Mr Graeme Williams
Project Manager
Building 31
The University of Wollongong
Wollongong NSW 2522

21/10/2019

The University of Wollongong - Western Building – Modification 2 (SSD-8596-Mod-2)
Request for Additional Information

GENERAL ARRANGEMENT LAYOUT
SCALE 1:100

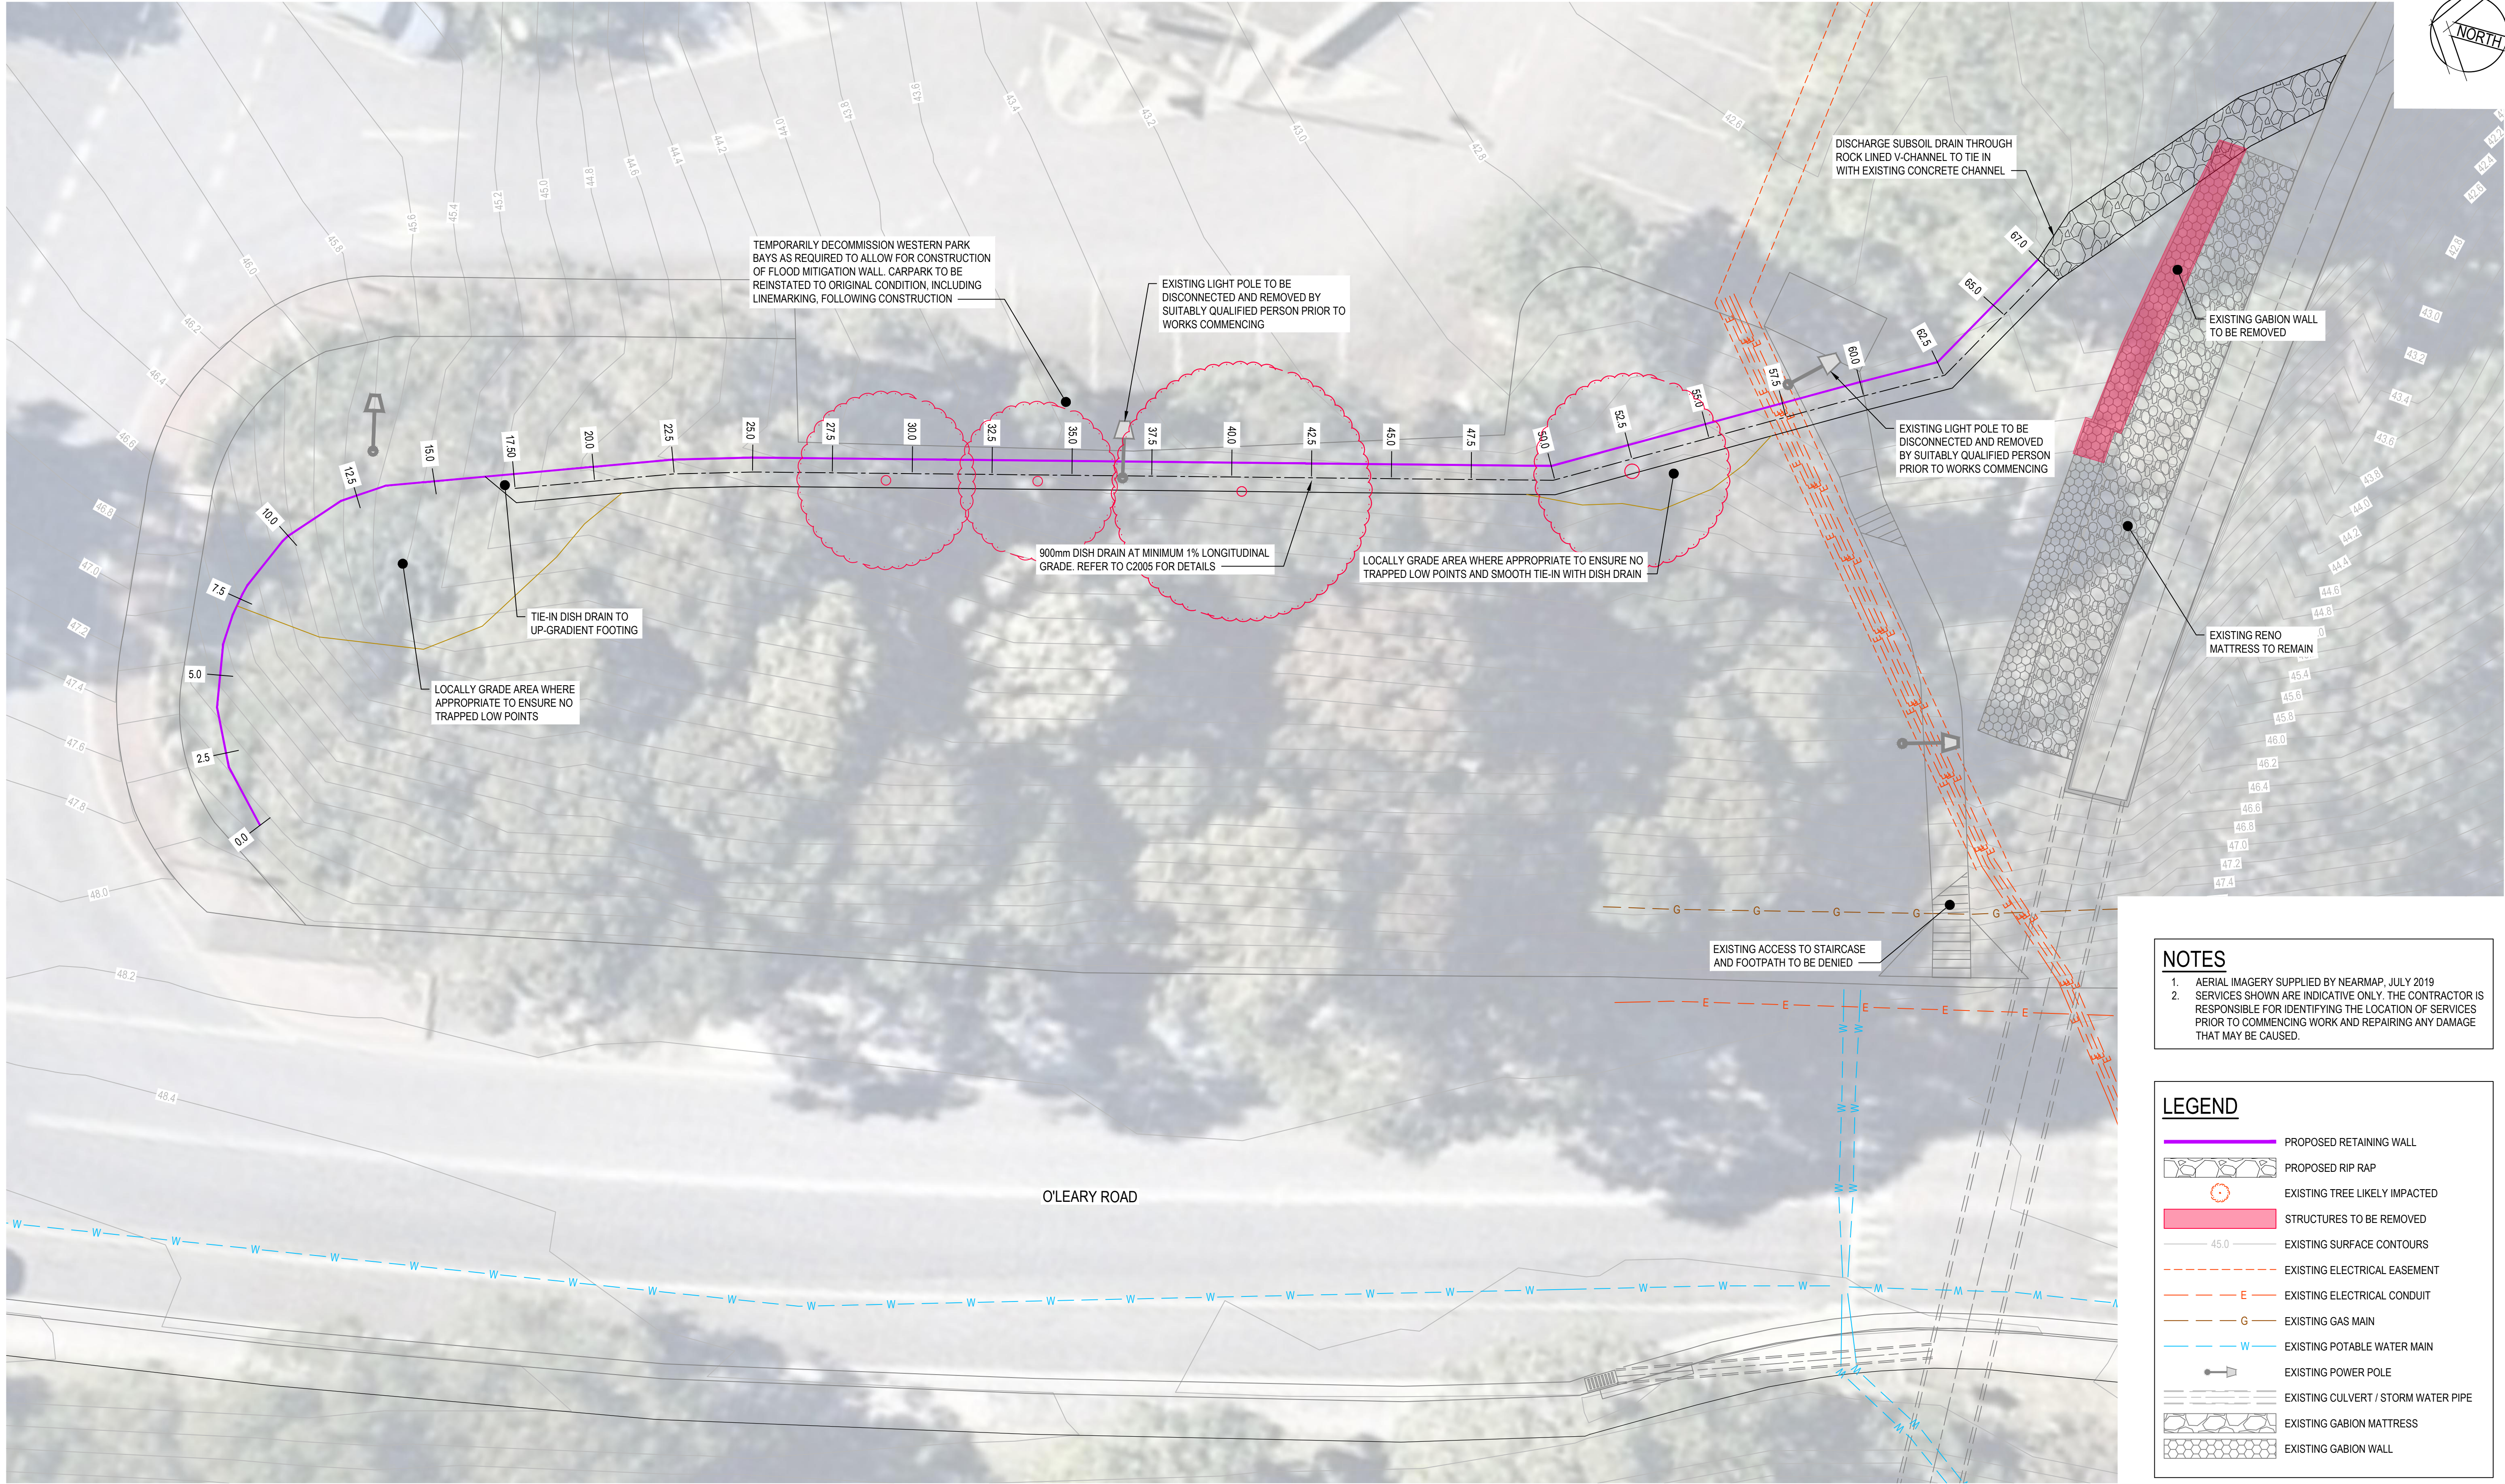
- Details of the proposed flood training wall, including:
 - the visibility of the flood training wall from O'Leary Road (or any other publicly accessible location).

- detail of how the flood training wall will adjoin the existing waterway that runs south east through the site and confirmation that this waterway has the capacity to manage the diverted flows.

- the materials of the retaining wall.
 - details of any clearing that will need to occur to enable construction of the retaining wall.
- Responses to the issues raised by the Department on the original SSD application regarding the flood training wall including:

- details of how the proposed flood wall will interact with any other aspects of building design or operations (e.g. the approved flood training walls, waste collection).

Client	UNIVERSITY OF WOLLONGONG
Project	O'LEARY ROAD FLOOD MITIGATION WALL DETAILED DESIGN
Title	RETAINING WALL LONGSECTION PLAN

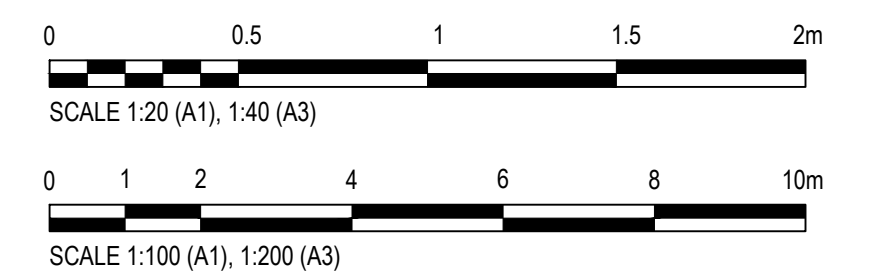
- details of the flood wall and localised grading/swale immediately adjacent to the flood wall.
 - both a section plan and elevation plan of the flood wall structure (showing height, width and length).
